Application number: 2020/93868	
What is the application for?:	Erection of single and two storey extensions
Address of the site or building:	58 , Southfield Road, Waterloo, Huddersfield, HD5 8RJ
Postcode:

User comments

| DRAWING TITLE<br>PROPOSED PLANS                                                                                                                                                                                                                                      |       |             |            |

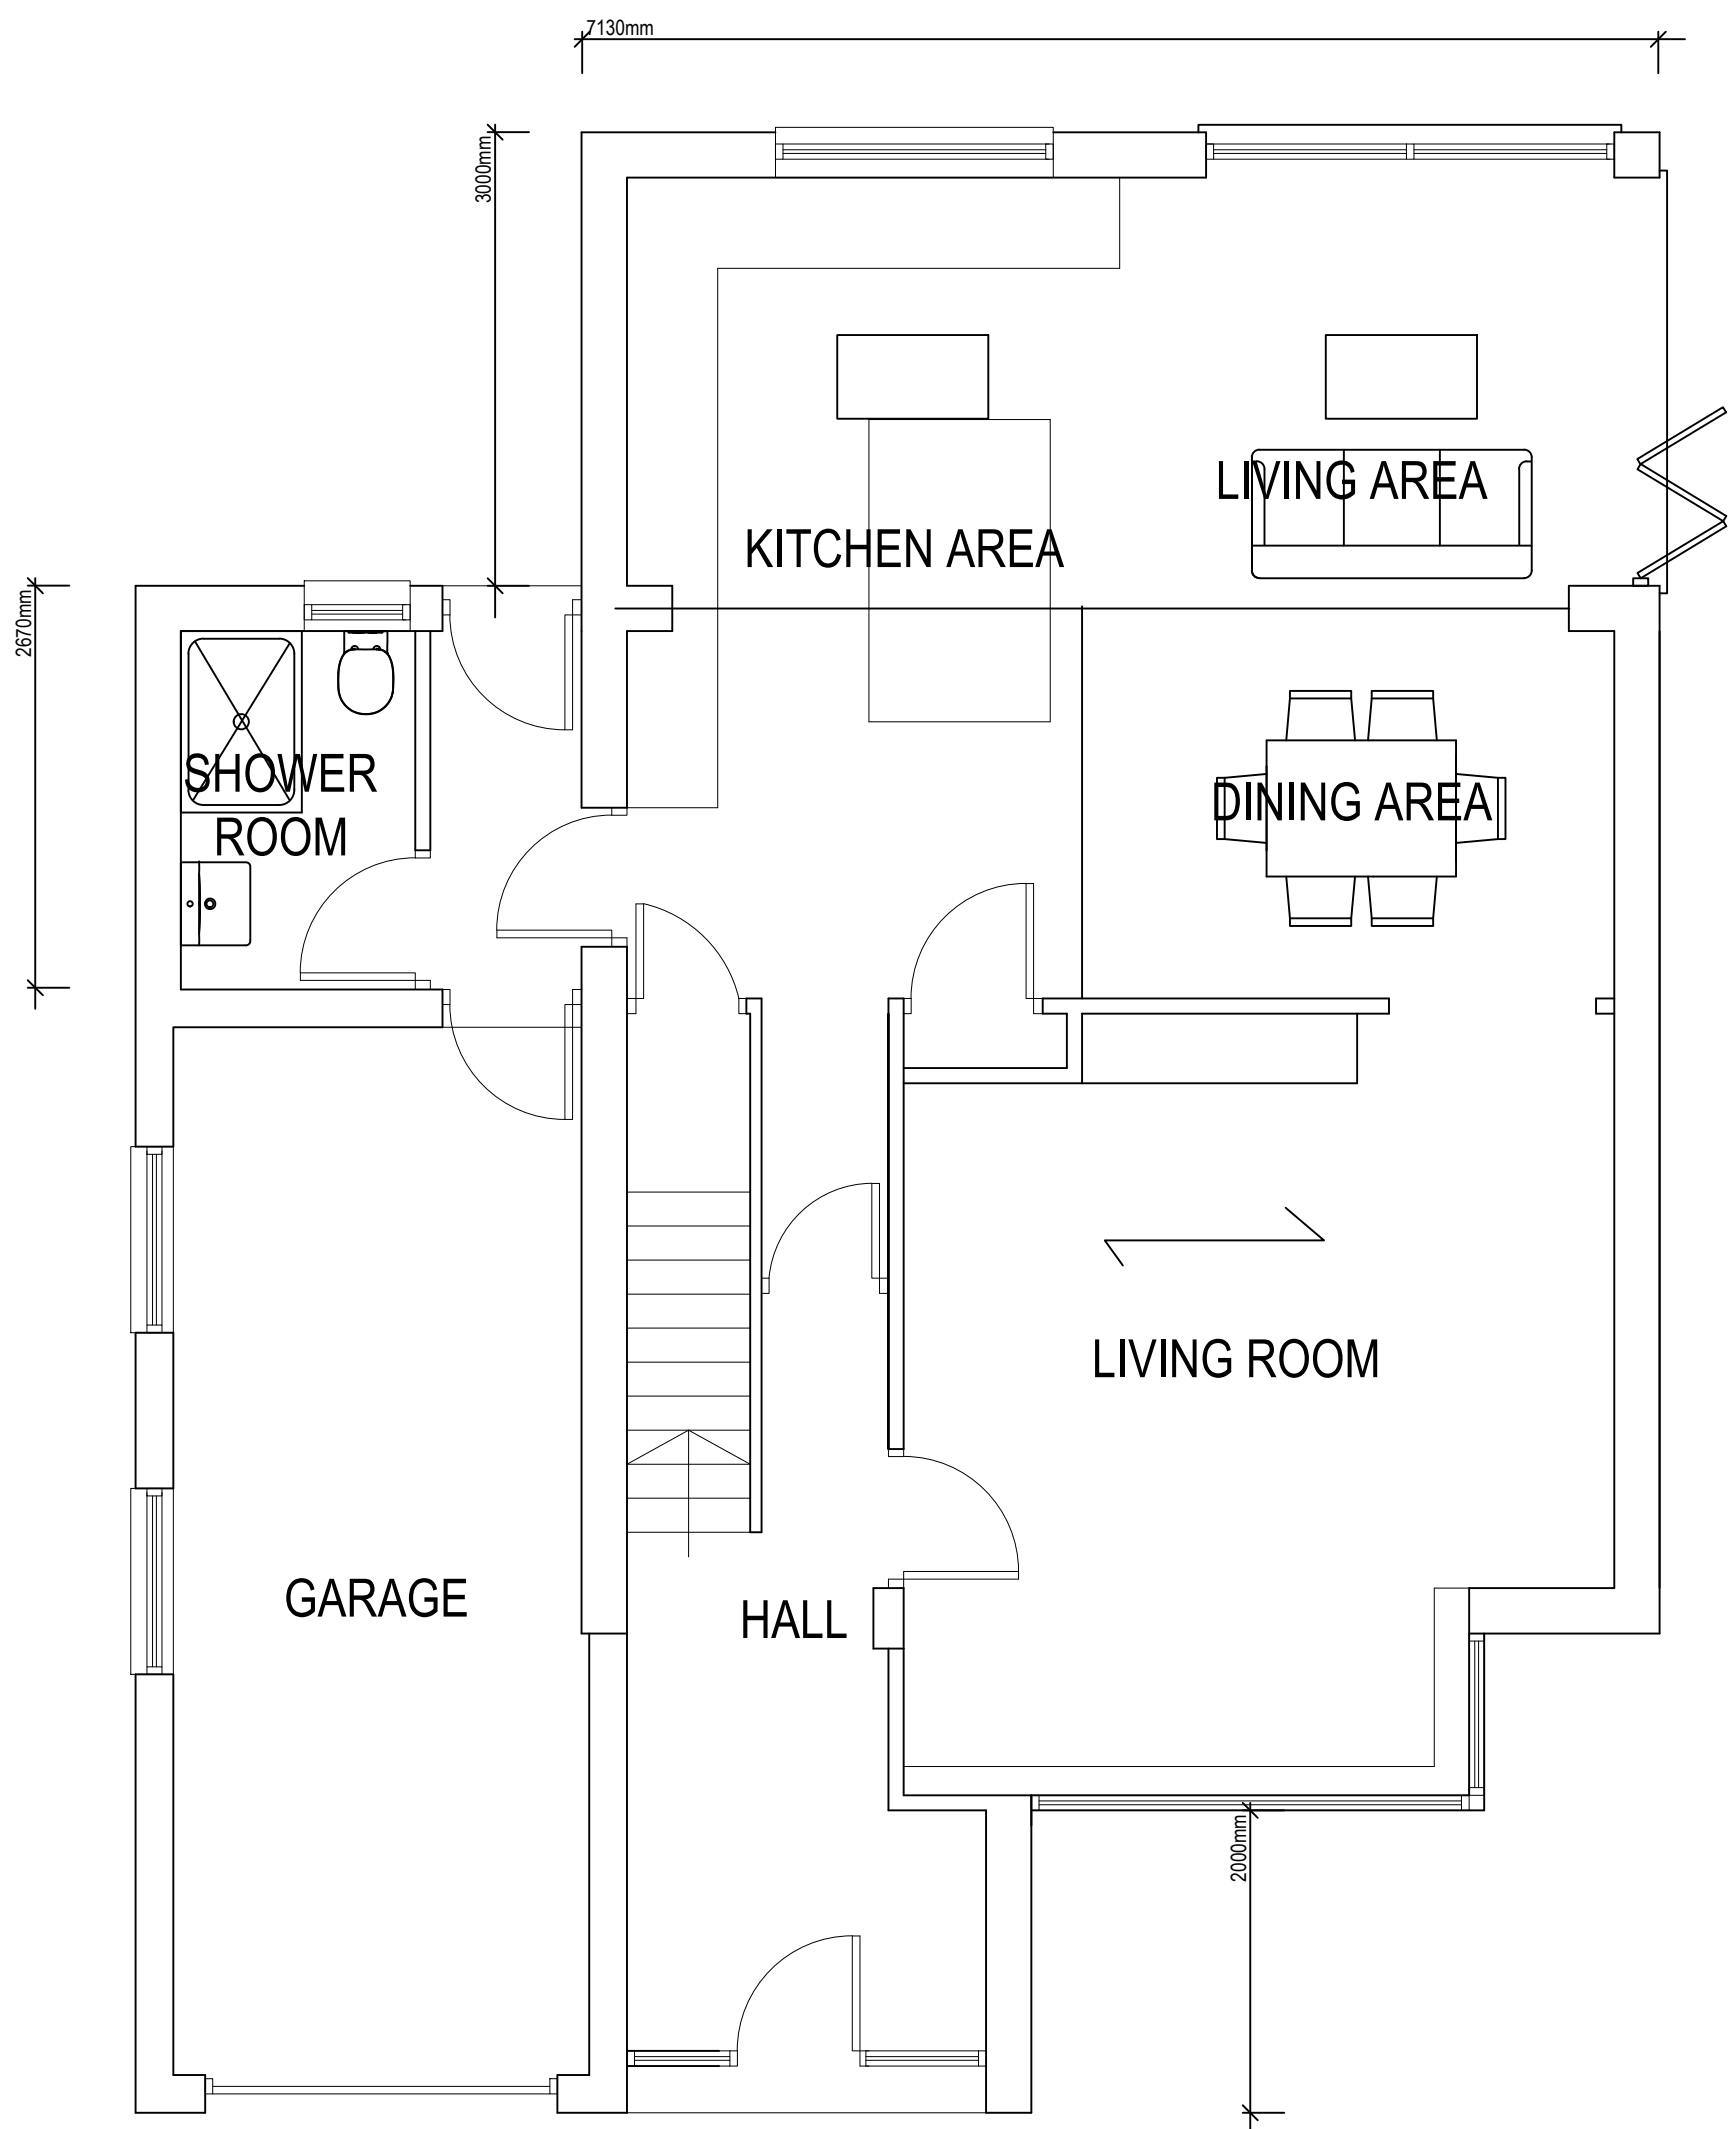
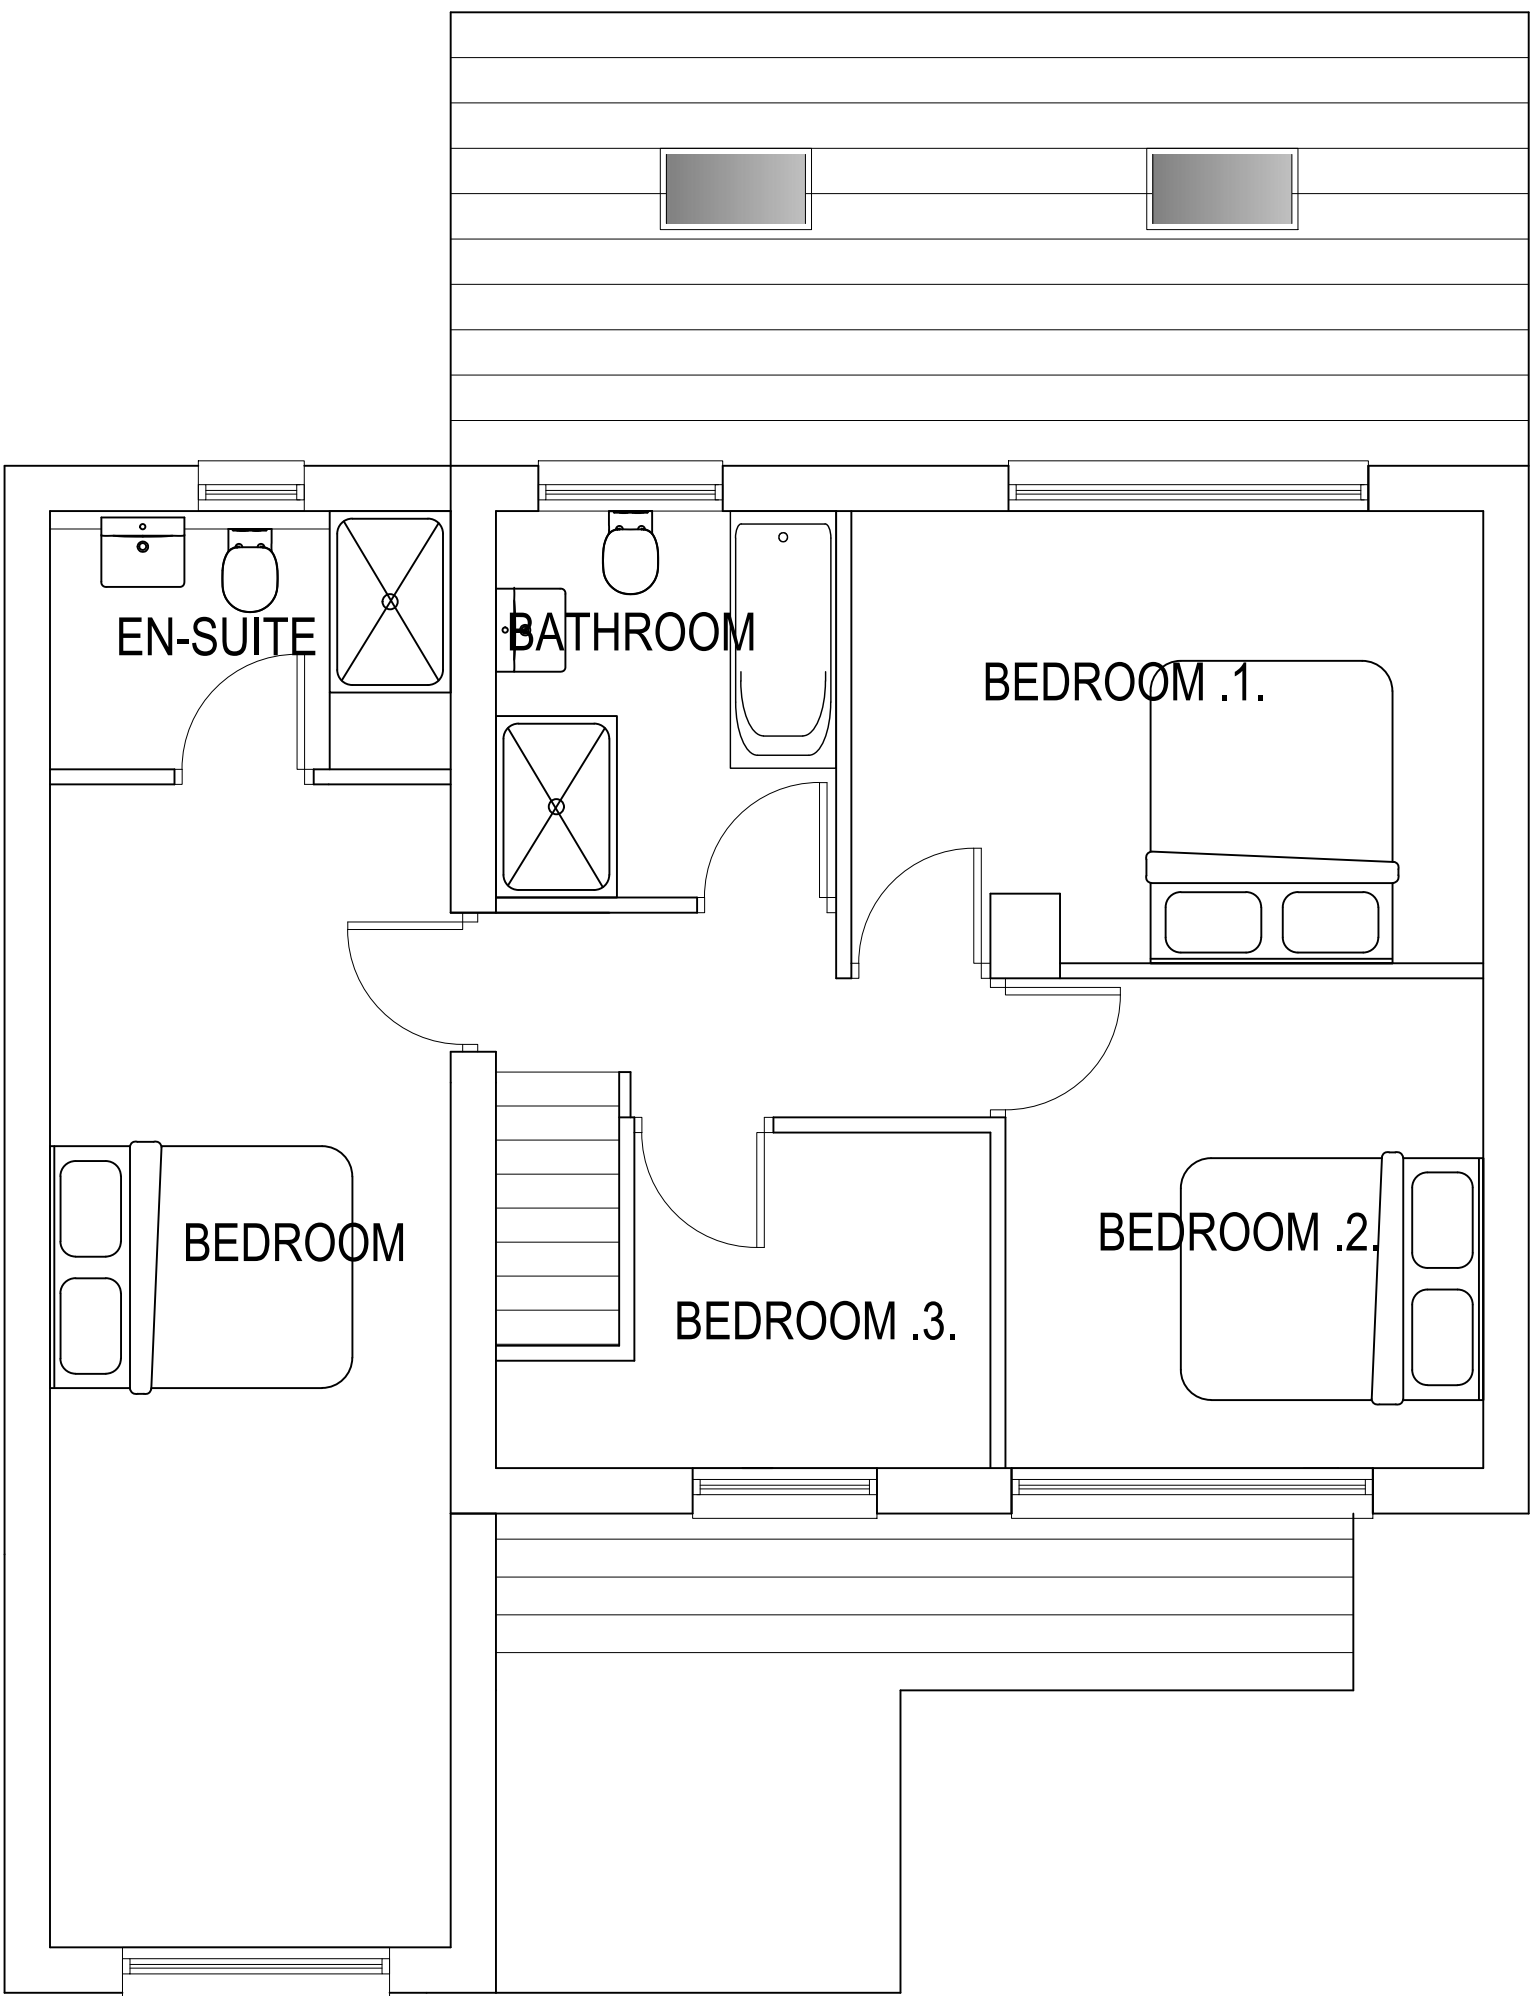
Type of comment: An objection
From looking at the plans it is clear that the proposed side extension is too big. This will have a dramatic effect on the lighting of the as the whole property will now be fully overshadowed and will also completely block Also this will look like no other property in the near vicinity.
